From: Sue Howell <Sue.Howell@arun.gov.uk>
Sent: 10 May 2021 17:39
To: Planning.Responses <Planning.Responses@arun.gov.uk>
Cc: Raymond Cole <Raymond.Cole@arun.gov.uk>
Subject: RE: Planning Consultation on: BN/18/21/RES

Application ref: BN/18/21/RES

Description: 5000 sq m of light industrial floor space (ClassB1 (b)/(c) following grant of outline planning permission WA/22/15/OUT (resubmission following BN/57/19/RES). This site is in CIL Zone 1 (Zero Rated) as other development.

Summary recommendation : Recommend approval of hard and soft landscape details contained within this BN/18/21/RES following grant of outline planning permission WA/22/15/OUT (resubmission following BN/57/19/RE

Drawing No
LLD1773-LAN-DWG-202
Revision
04

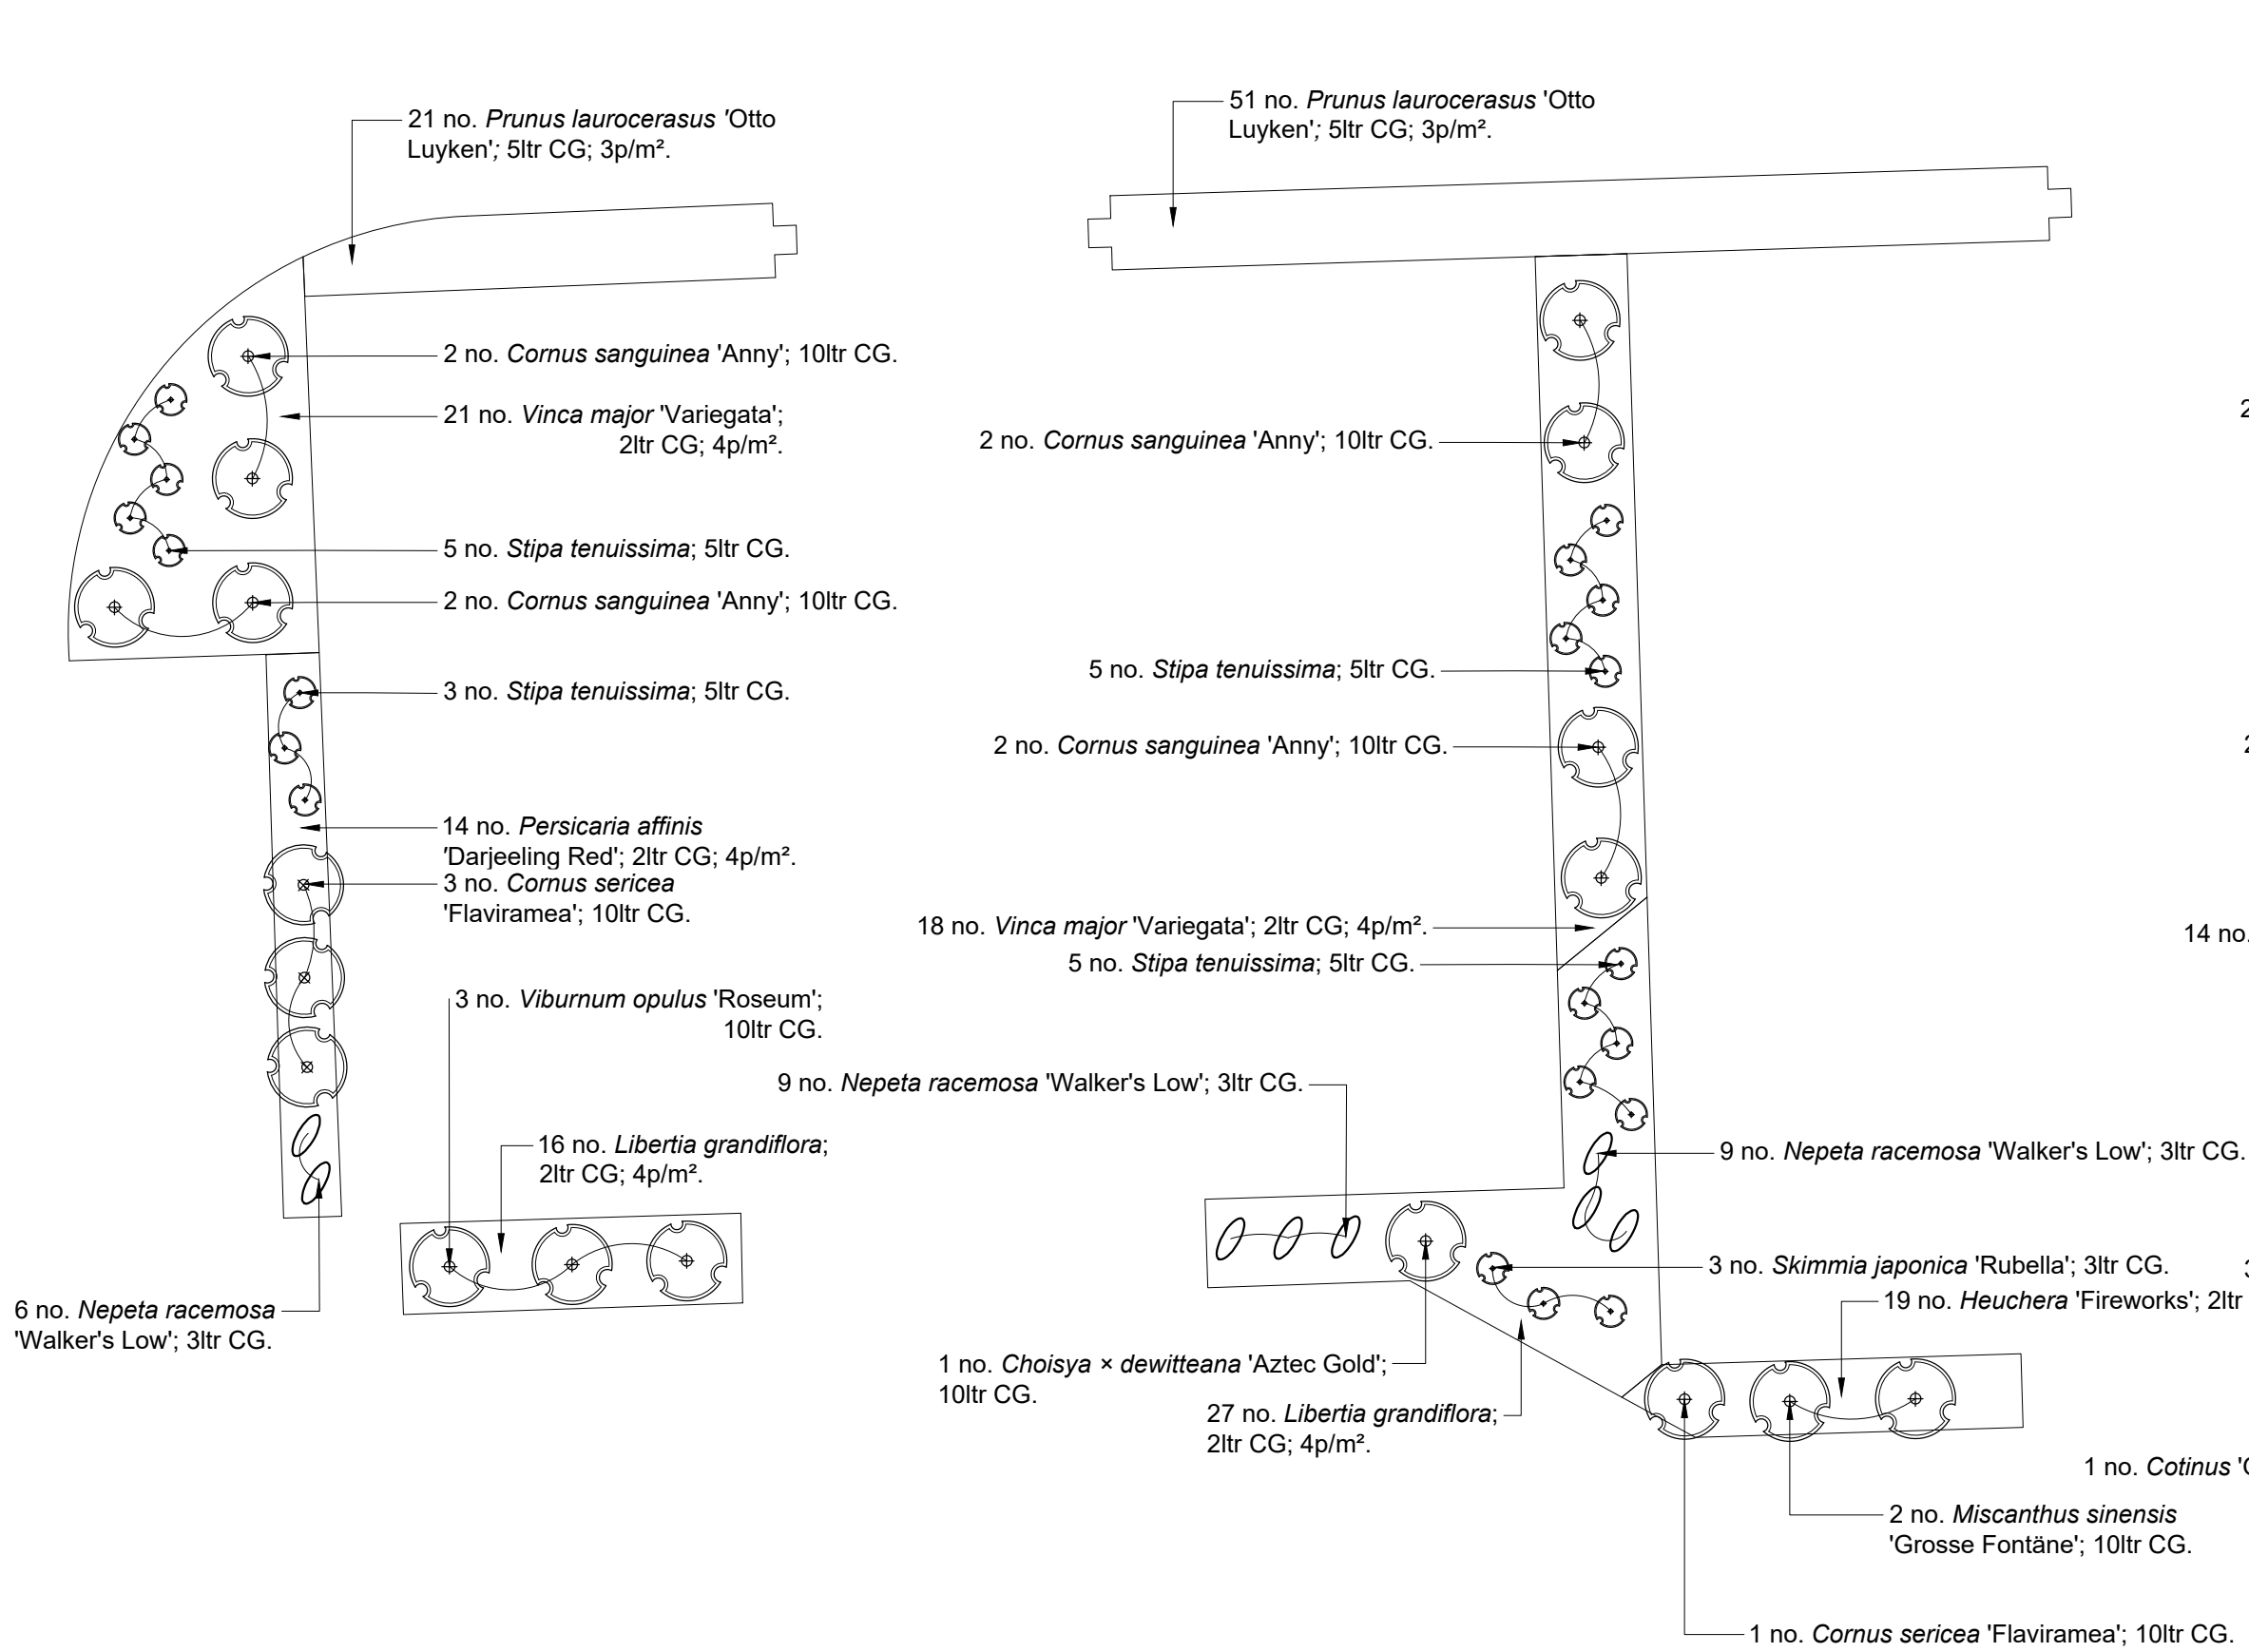
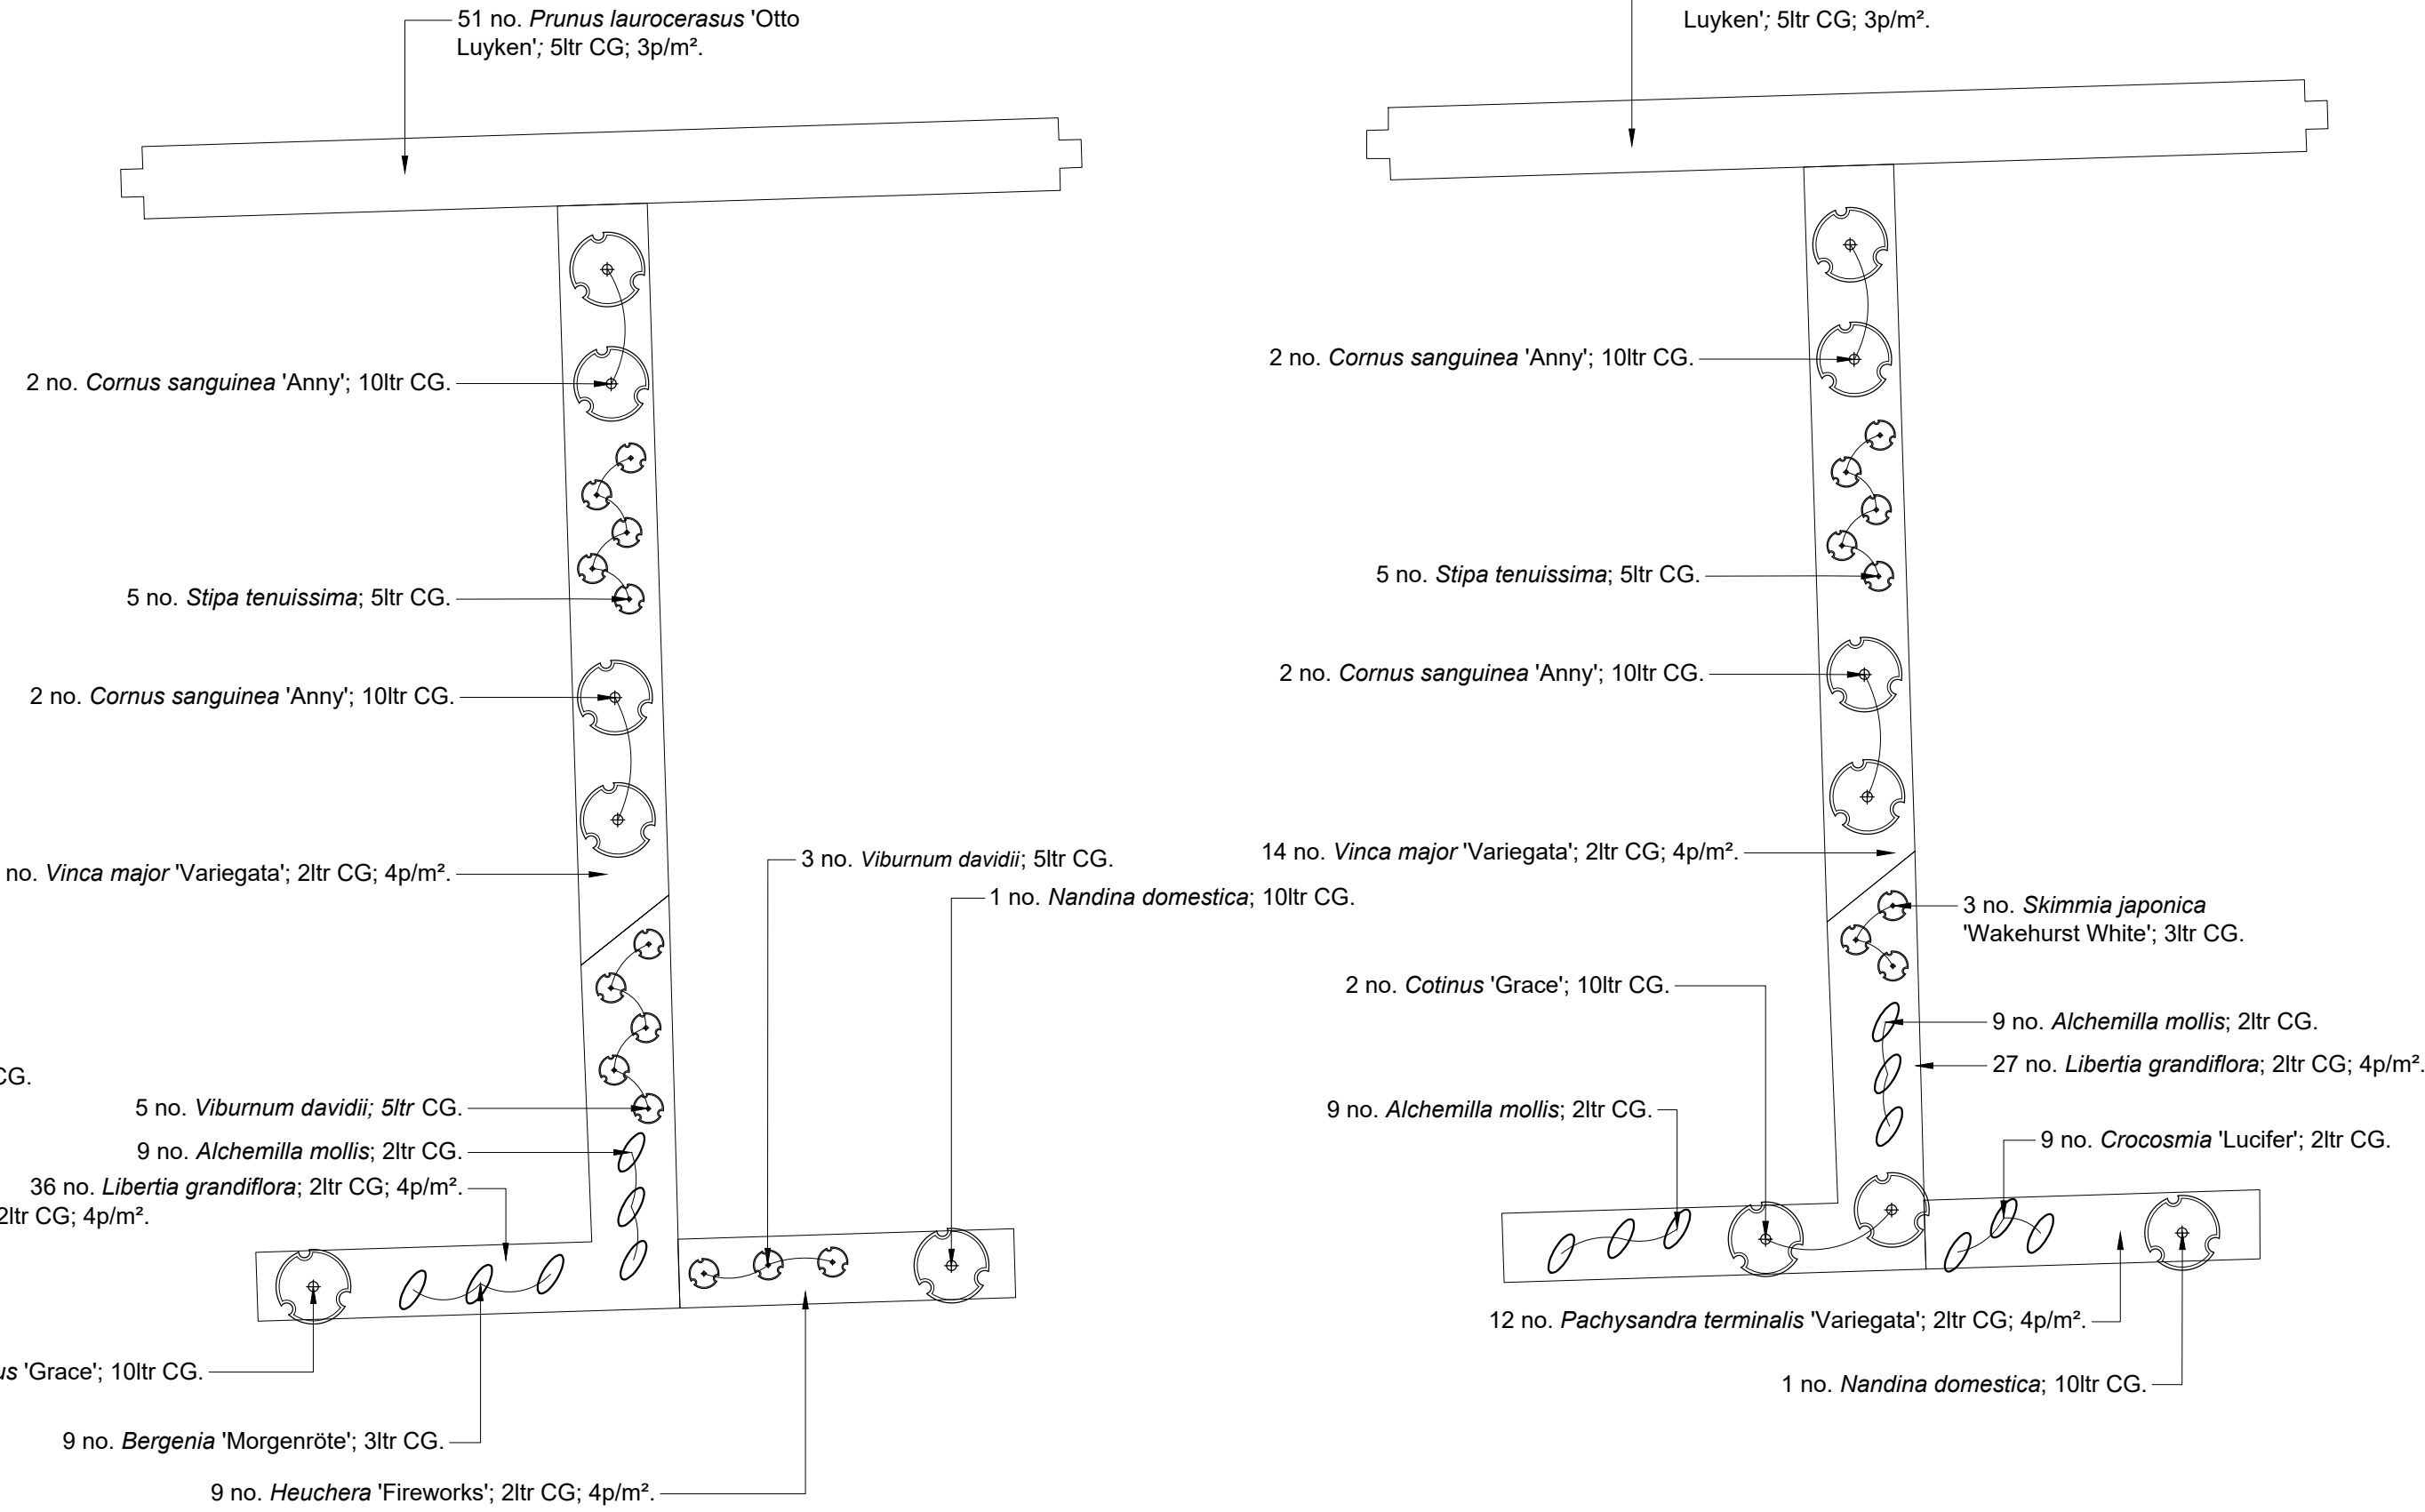
The information contained in Soft and Hard Landscape GA LLD-1773-LAN-DWG-100-REV10, Detailed planting plan ornamental planting LLD-1773-LAN-DWG-201-REV05, Detailed planting plan infrastructure planting LLD-1773-LAN-DWG-200-REV07, Detailed planting plan ornamental planting LLD-1773-LAN-DWG-202-REV04 proposes a well thought out and comprehensive scheme with trees, hedges, native planting, shrubs, grasses and buffer edge. The proposed scheme contains a good mix which will provide softening/screening improving the setting, increasingly over time as the planting matures. The scheme is adequately detailed with quantities and size at time of planting, providing trees which will add instant impact a species mix across the proposals both deciduous and evergreen which will add good biodiversity benefit to the site.
